CHIPPENHAM WITHOUT PARISH COUNCIL

STATEMENT OFH2 Tuesday 30 June 2026

LIME DOWN SOLAR PARK – EN010168

Title:
Figure 3-2-6: Key Construction Phase Features
Cable Route Corridor

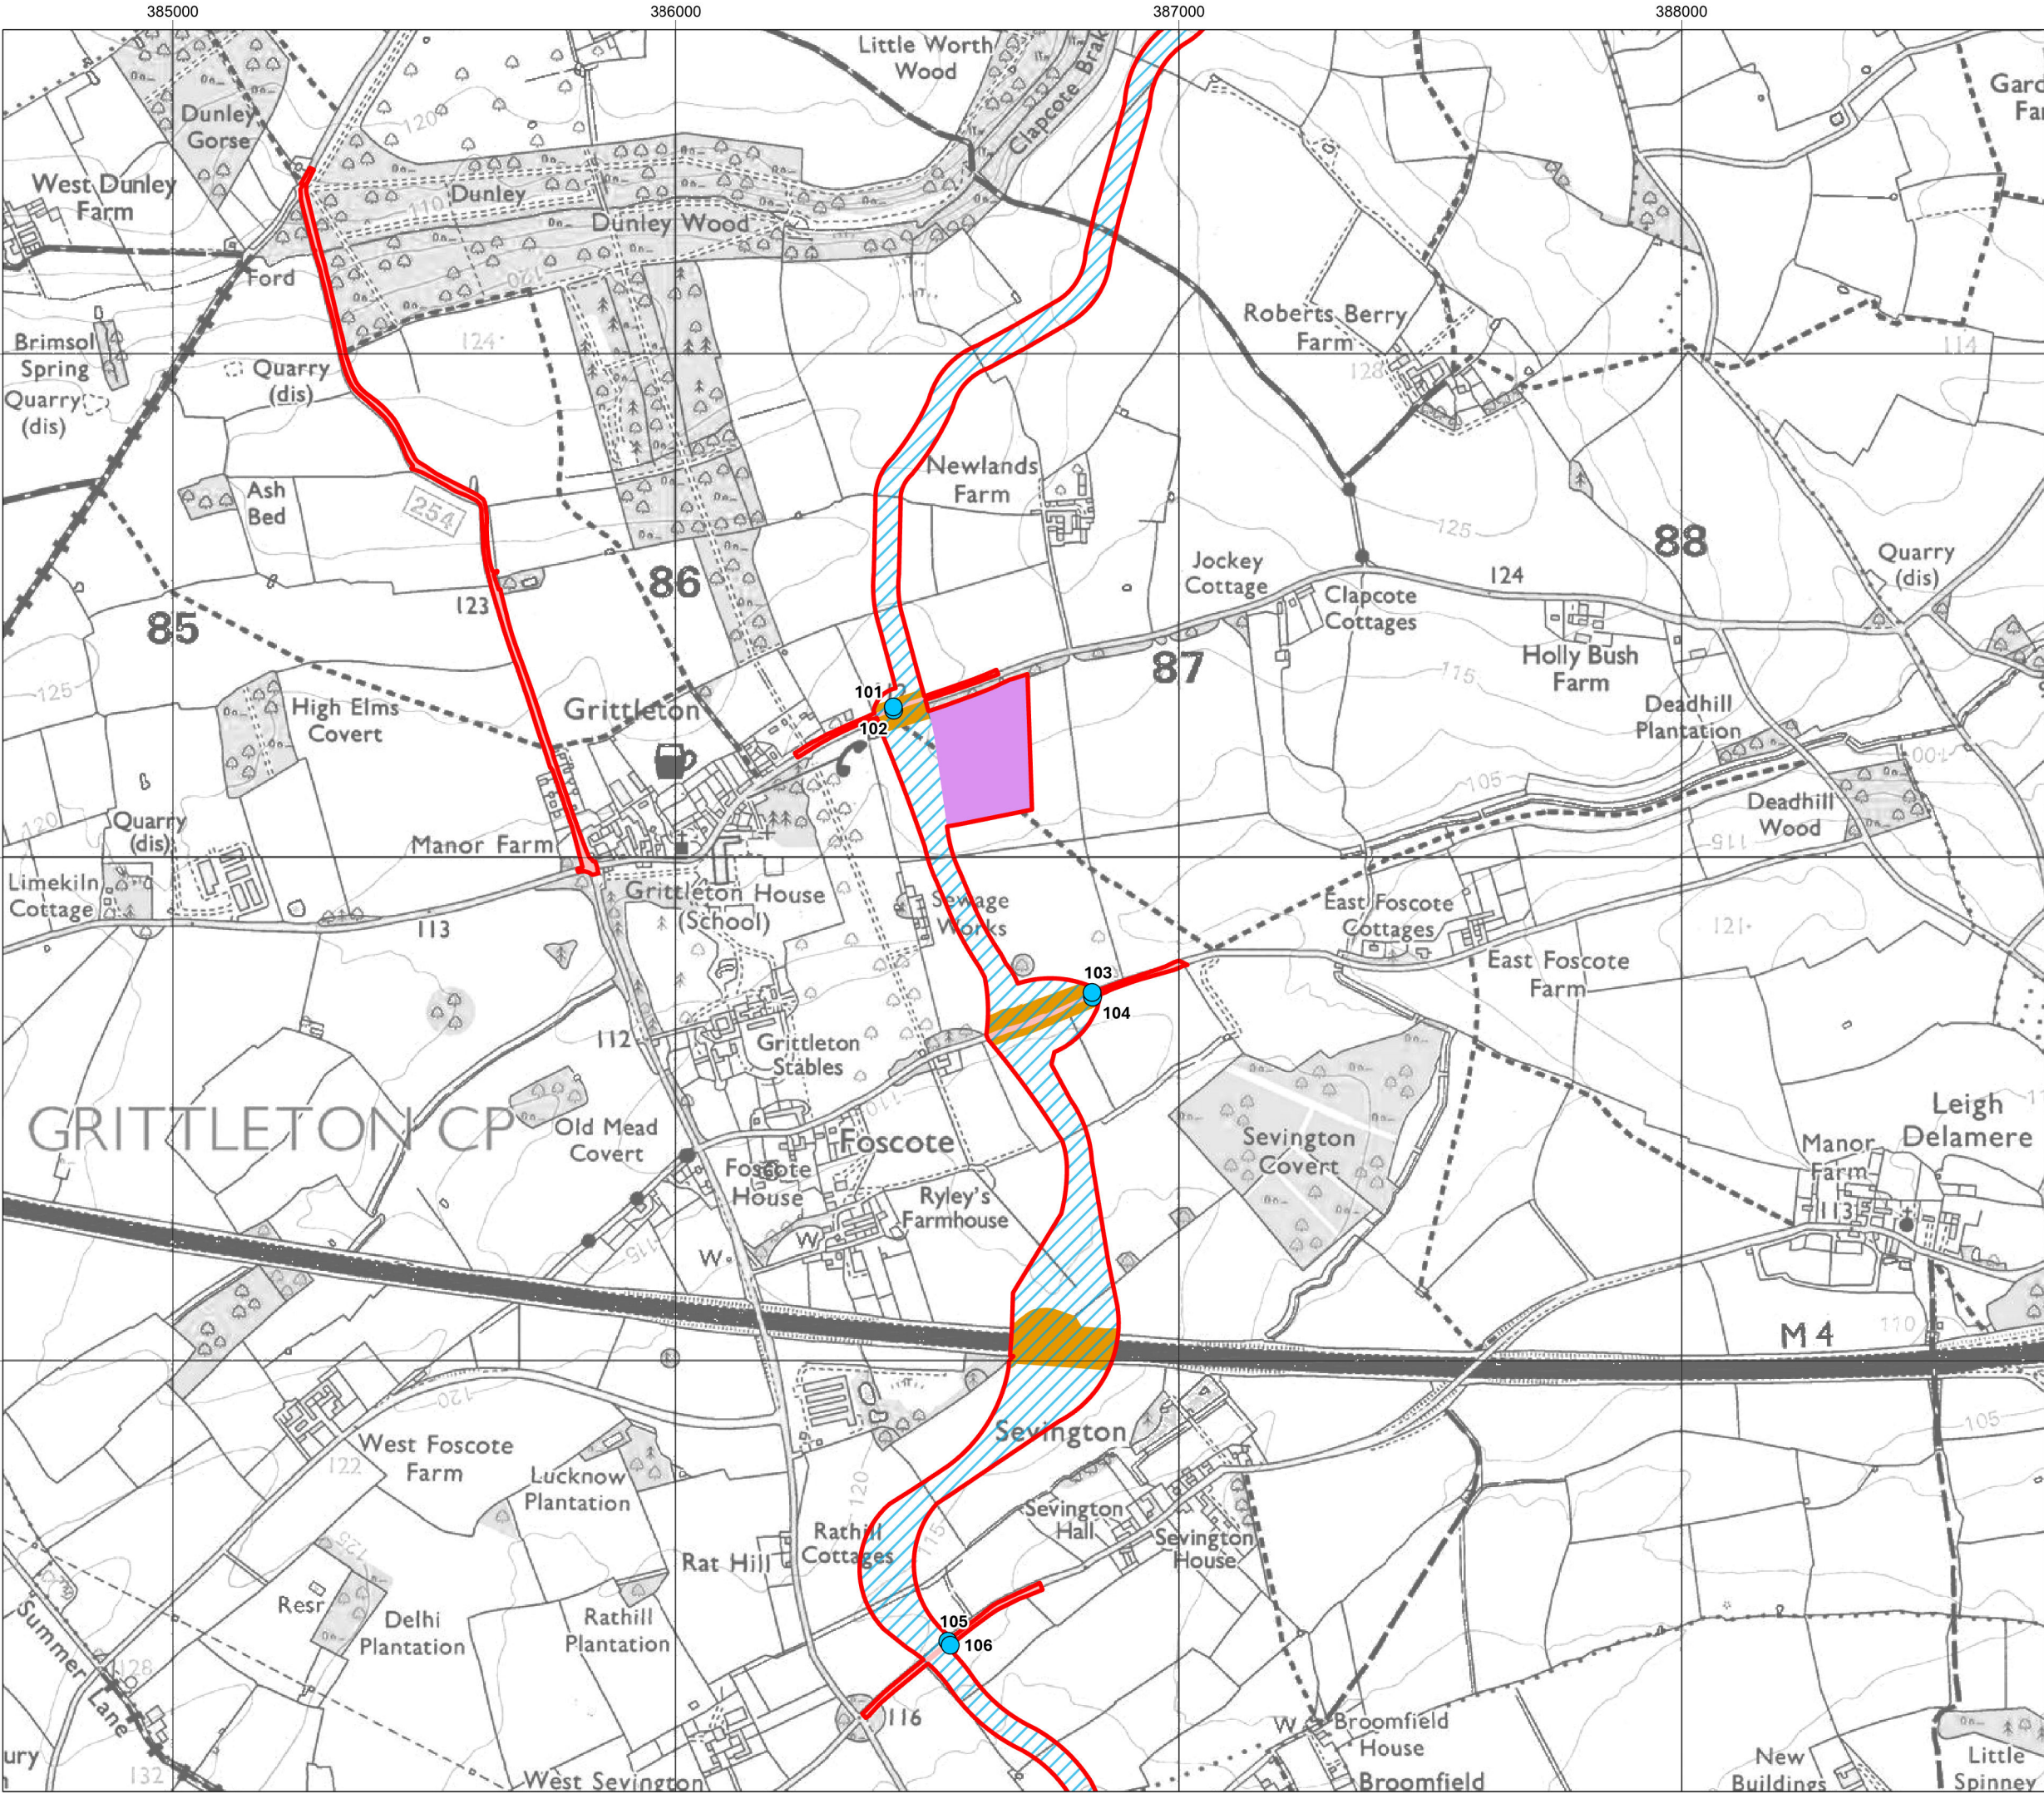
One site is within the Parish in the field bordered by Fowlswick Lane and the B4039, the through route from the A420 to Yatton Keynell, with the Golf Driving Range to the North. (DWG. B supplied identifies this)

Access to this field is proposed from Fowlswick Lane about 200 metres from the existing crossroads. The proposed opening serving an access track will require considerable enlargement and metaling, as will the Fowlswick Lane itself, which would need to be widened down to the crossroads. (Identified yellow on DWG. B)

This will potentially require the removal of the mature hedgerow along the 200 metre length with verge and also have highway drainage implications. The existing crossroads is a known accident black spot and is far from ideal for use by plant and heavy vehicles.

The other potential access to this field is proposed to be directly onto the B4039, on the western boundary of the field, which is also a traffic hazard and which will require a large splayed access, with significant visibility splays and signage and a reduction in speed limit. (Identified green on DWG. B)

It is considered that if either access proposal was adopted the entire length of mature hedgerow on the B4039 in the northern direction would need removal and replaced along a new visibility line to the crossroads. The change in landscape of this rural area required by these works to facilitate a safe highway arrangement would have significant detrimental impact on the overall character of the area.

Title:
Figure 3-2-9: Key Construction Phase Features
Cable Route Corridor

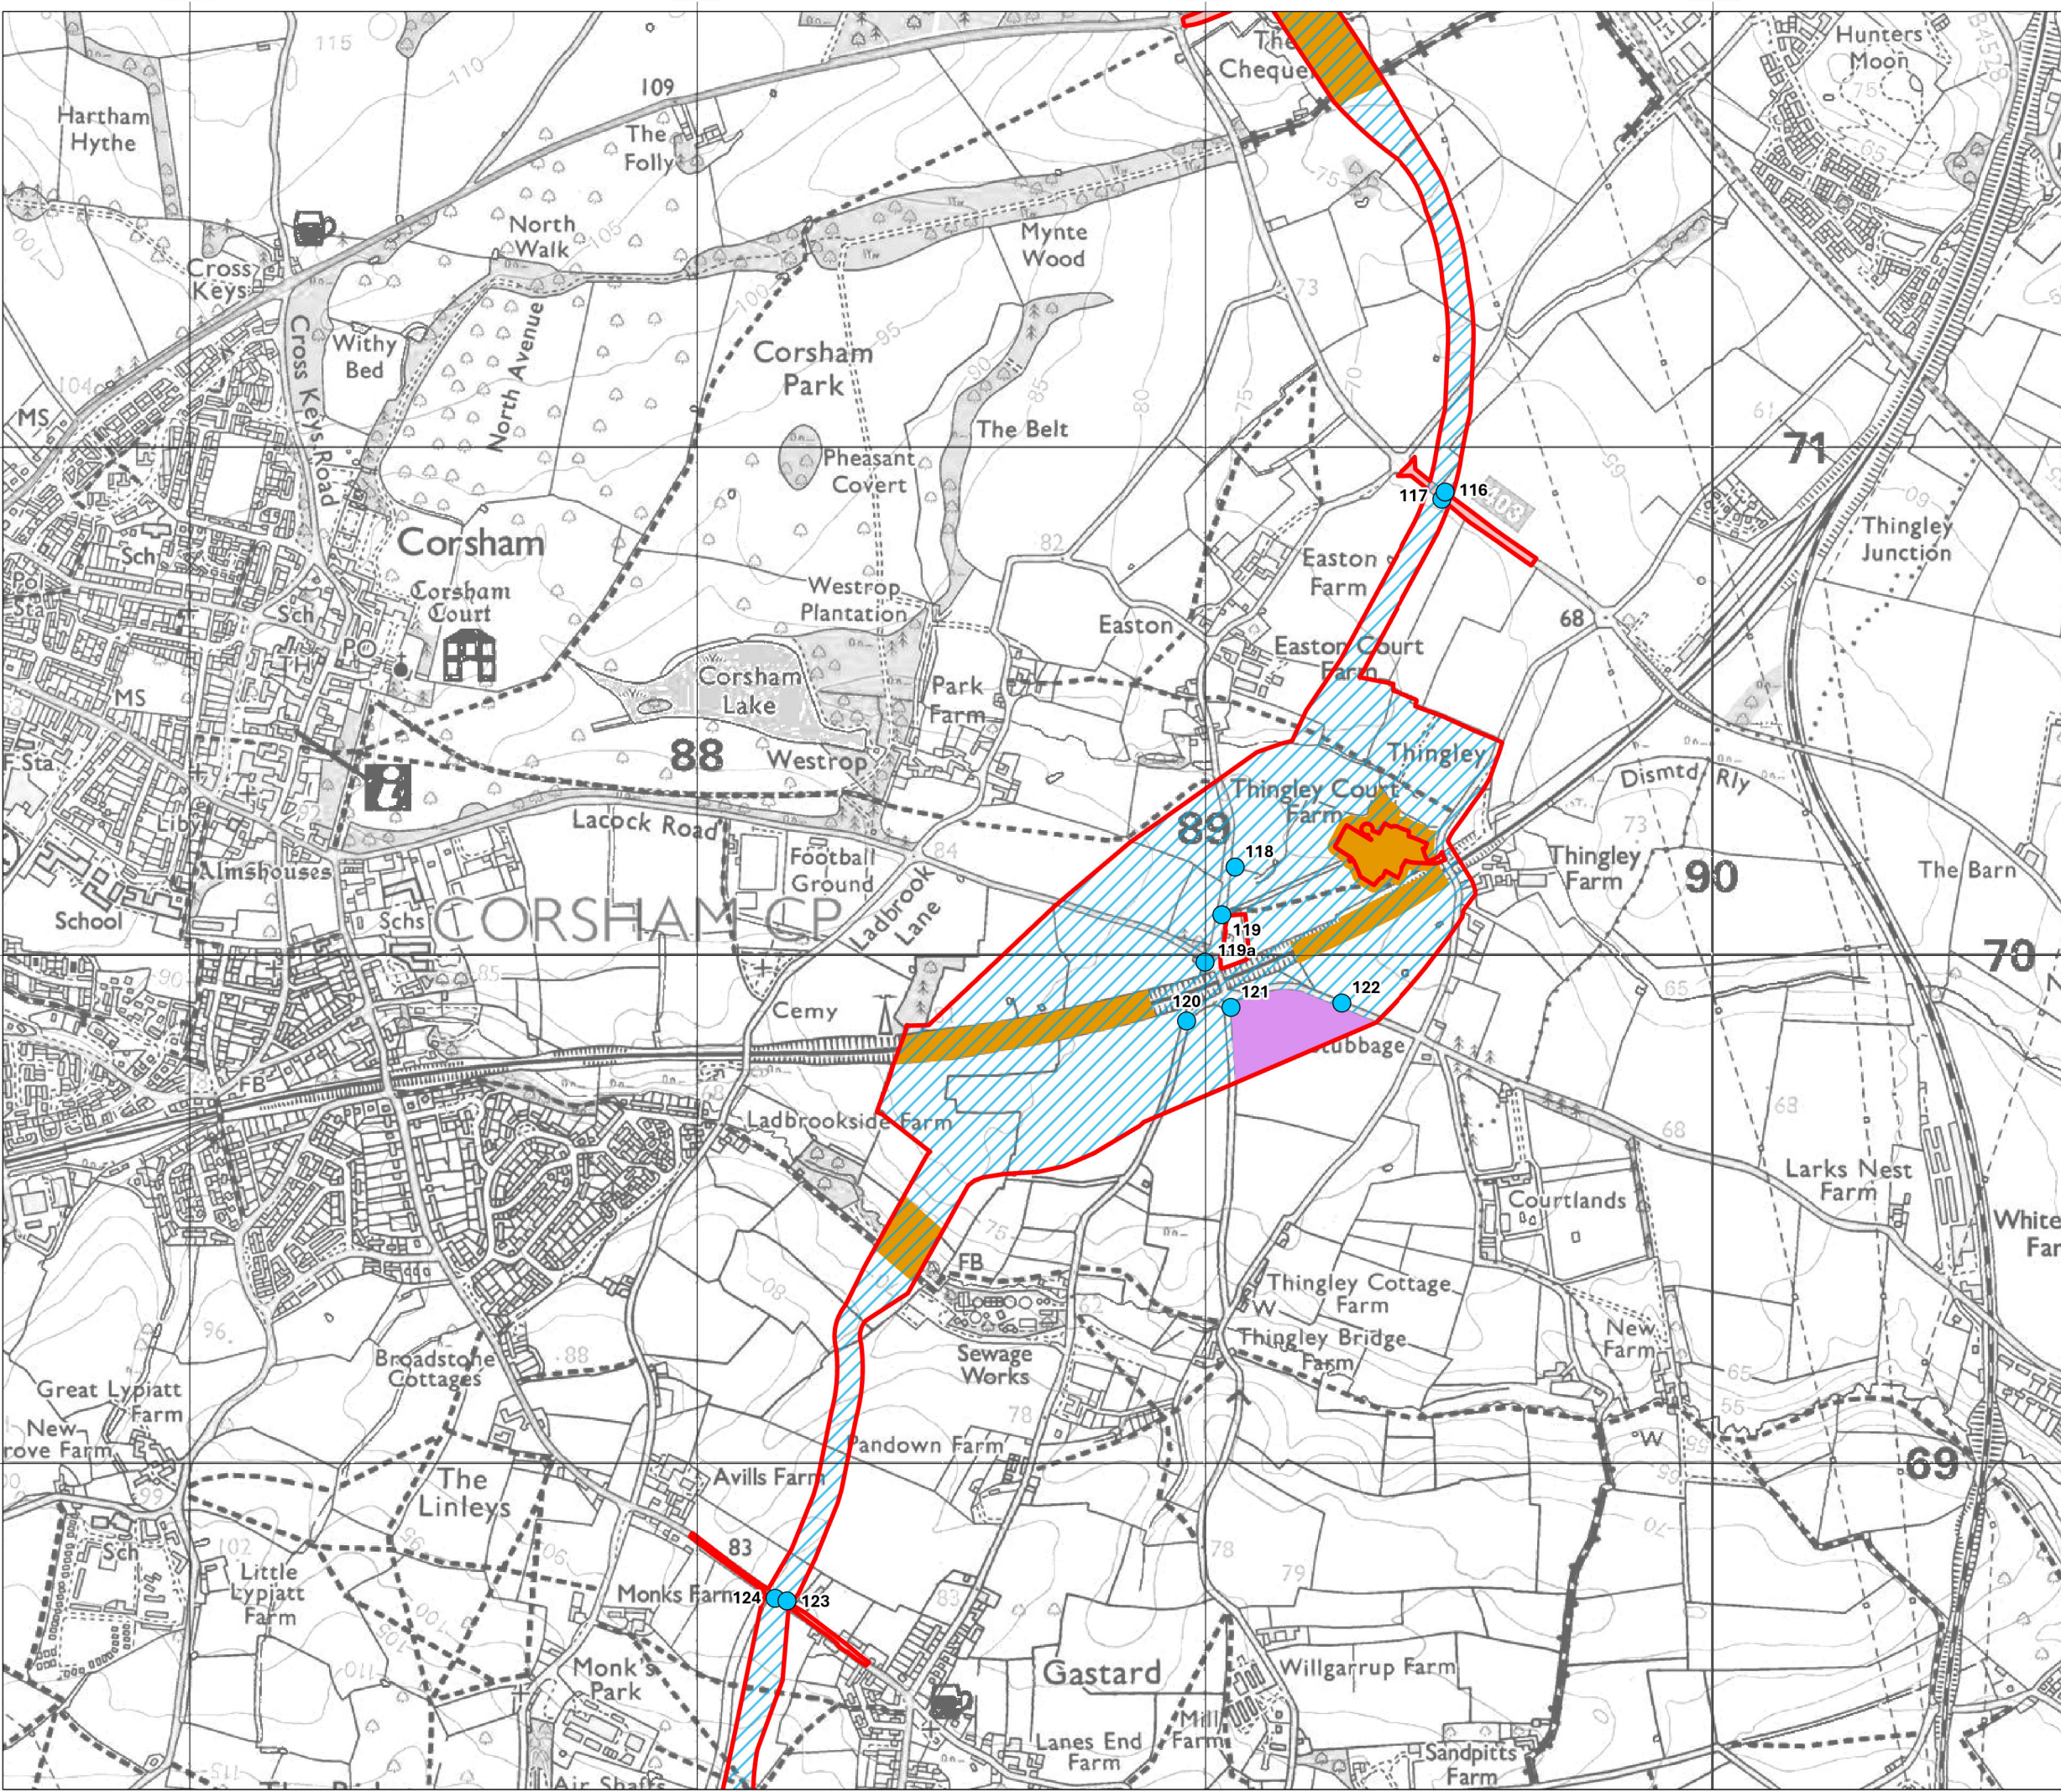
The second proposed site borders the Parish in a field opposite Showell Farm, not within the Parish, but the problem here is again one of access, which will have to be off the narrow Corsham Lane. (DWG. A supplied identifies this)

However, Chippenham Without Parish has a significant interest in that the route to and from the proposed site is likely to be along Corsham Lane via Sheldon Corner and the A420 Allington Farm crossroads. (Identified yellow on DWG. A) The reason being that while the access using the Corsham Lane off the A4 is feasible for large construction traffic, exiting back on to the A4 would be difficult and extremely dangerous. (Identified green on DWG. A)

Consequently, as other narrow country lanes towards Chequers Farm and Biddestone are entirely impractical for heavy use, it is considered that access to this site would therefore have to be through the Parish. Thus, there will be considerable highway safety implications and potential disruption to this often rat run narrow artery of the Parish especially at the joining local lane junctions, the Sheldon Corner blind spot and the A420 Allington Farm crossroads which will be totally unacceptable from a highway safety point of view as all are existing accident black spots.
